Re: Exhibition of Modification to State Significant Development Application for Warehouse and Distribution Centre, Prestons (SSD 7155 MOD 7)

Company		Job No./Drawing No.	Title	Revision /Issue	Date
Costin Consulting	Roe	Co8753.21	Civil Engineering Report for SSD7155 Mod 7	C	13.09.18
Costin Consulting	Roe	CO8753.21-C10	DRAWING LIST & GENERAL NOTES	B	17.08.18
Costin Consulting	Roe	CO8753.21-C20	EROSION & SEDIMENT CONTROL PLAN	A	17.08.18
Costin Consulting	Roe	CO8753.21-C25	EROSION & SEDIMENT CONTROL DETAILS	A	17.08.18
Costin Consulting	Roe	CO8753.21-C30	BULK EARTHWORKS PLAN	A	17.08.18
Costin Consulting	Roe	CO8753.21-C35	BULK EARTHWORKS SECTIONS SHEET 1	A	17.08.18
Costin Consulting	Roe	CO8753.21-C36	BULK EARTHWORKS SECTIONS SHEET 2	A	17.08.18
Costin Consulting	Roe	CO8753.21-C40	STORMWATER DRAINAGE PLAN	B	17.08.18
Costin Consulting	Roe	CO8753.21-C42	STORMWATER CATCHMENT PLAN	A	17.08.18
Costin Consulting	Roe	CO8753.21-C45	STORMWATER DRAINAGE DETAILS	B	17.08.18
Costin Consulting	Roe	CO8753.21-C47	OSD PLAN & DETAILS	B	17.08.18
Costin Consulting	Roe	CO8753.21-C48	OSD PLAN & DETAILS – SHEET 2	A	17.08.18

STORMWATER CATCHMENT PLAN
1:500 SCALE

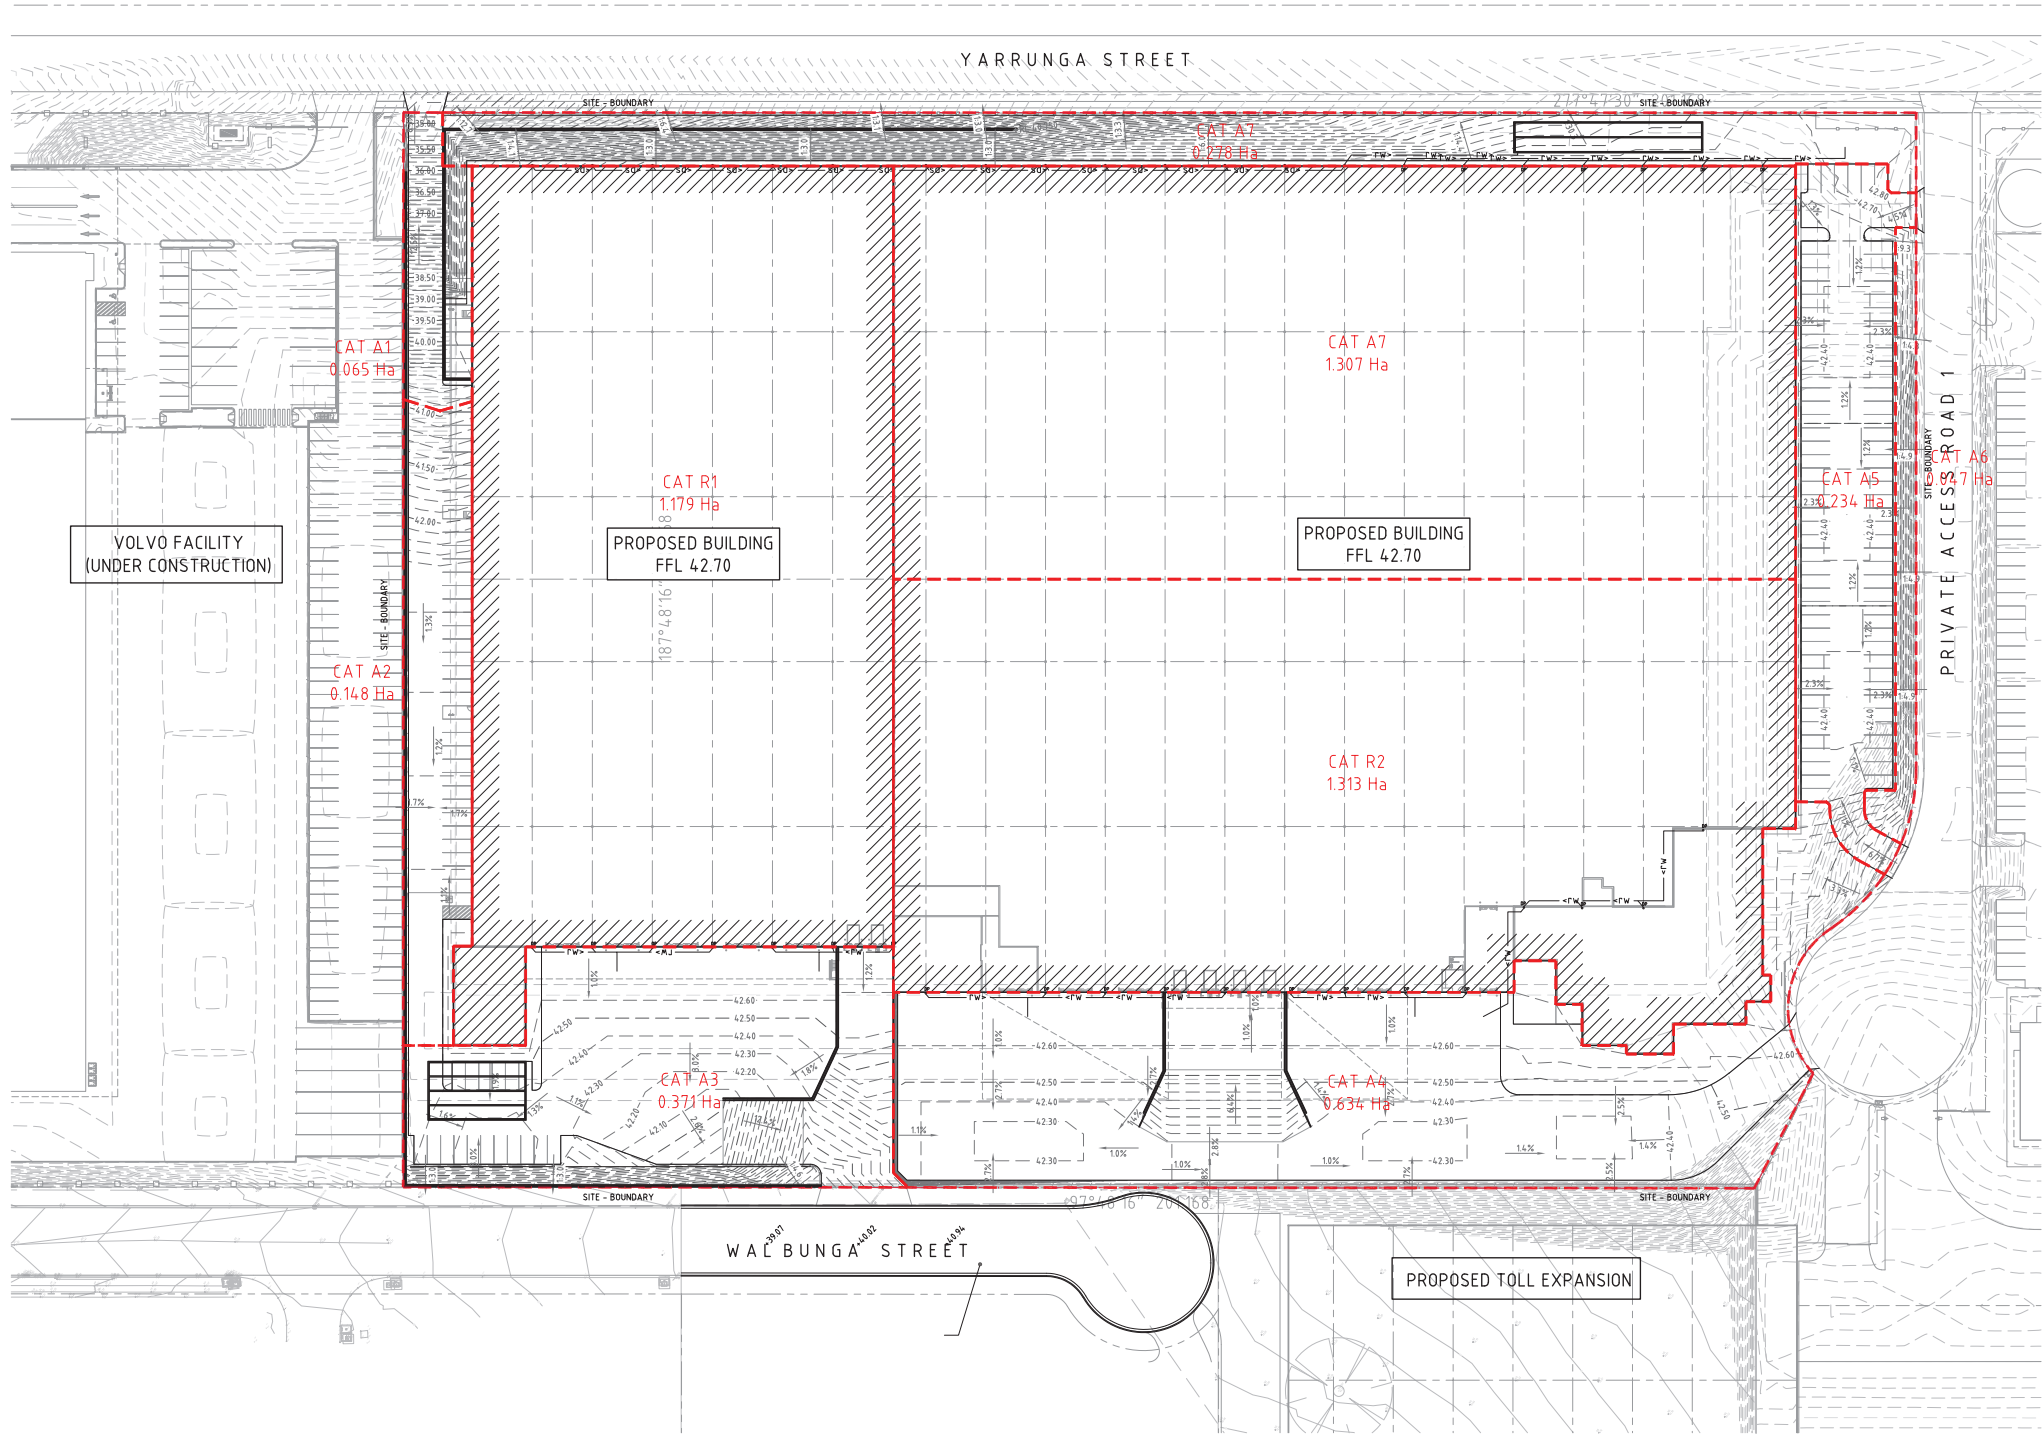
5. A stormwater drainage system shall be provided generally in accordance with the concept plan/s lodged for development approval, prepared by Costin Roe Consulting, reference number C08753.21-C40, Revision B, Dated:17.08.18.

- a) The proposed development and stormwater drainage system shall be designed to ensure that stormwater runoff from upstream properties is conveyed through the site without adverse impact on the development or adjoining properties.

- b) Engineering plans and supporting calculations for the stormwater drainage system are to be prepared by a suitably qualified engineer and shall accompany the application for a Construction Certificate. The plan shall indicate the method of disposal of all stormwater and must include rainwater tanks, existing ground levels, finish surface levels and sizes of all pipes.

- c) Prior to the issue of a Construction Certificate the Certifying Authority shall ensure that the stormwater drainage system has been designed in accordance with Liverpool City Council's Design Guidelines and Construction Specification for Civil Works.

REINFORCED EARTH RETAINING WALL
SCALE 1:20

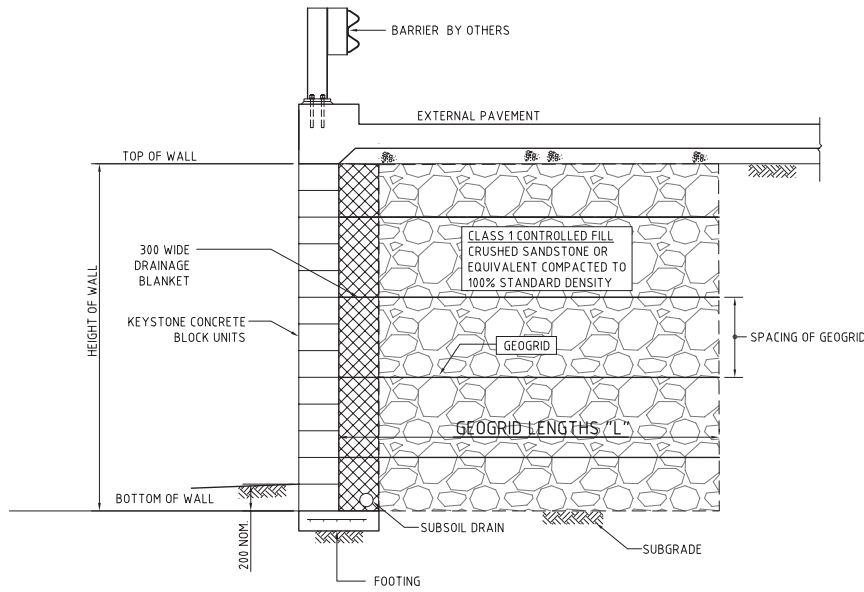
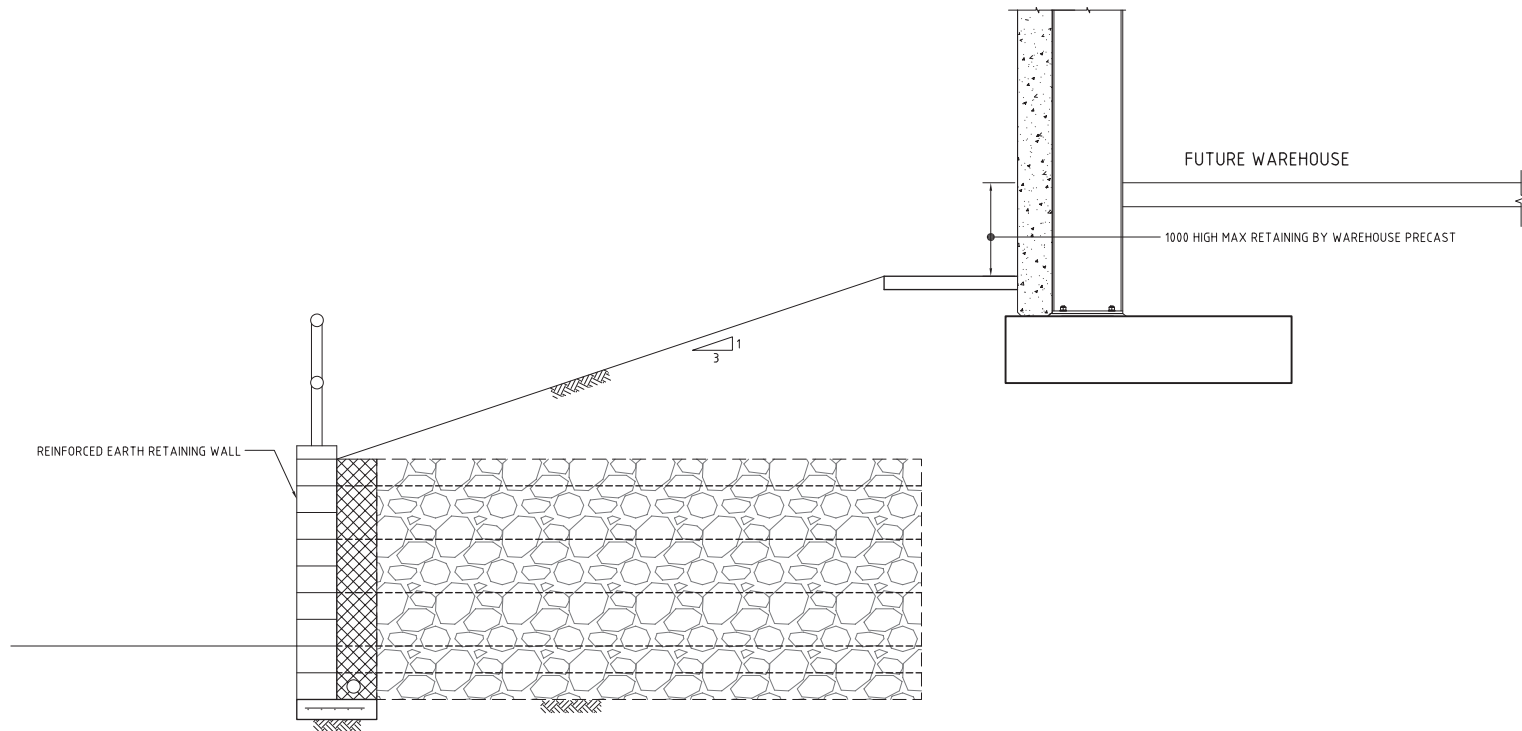
3. All retaining walls shall be of masonry construction and must be wholly within the property boundary, including footings and agricultural drainage lines. Construction of retaining walls or associated drainage works along common boundaries shall not compromise the structural integrity of any existing structures.

Where a retaining wall exceeds 600mm in height, the wall shall be designed by a practicing structural engineer and a construction certificate must be obtained prior to commencement of works on the retaining wall.
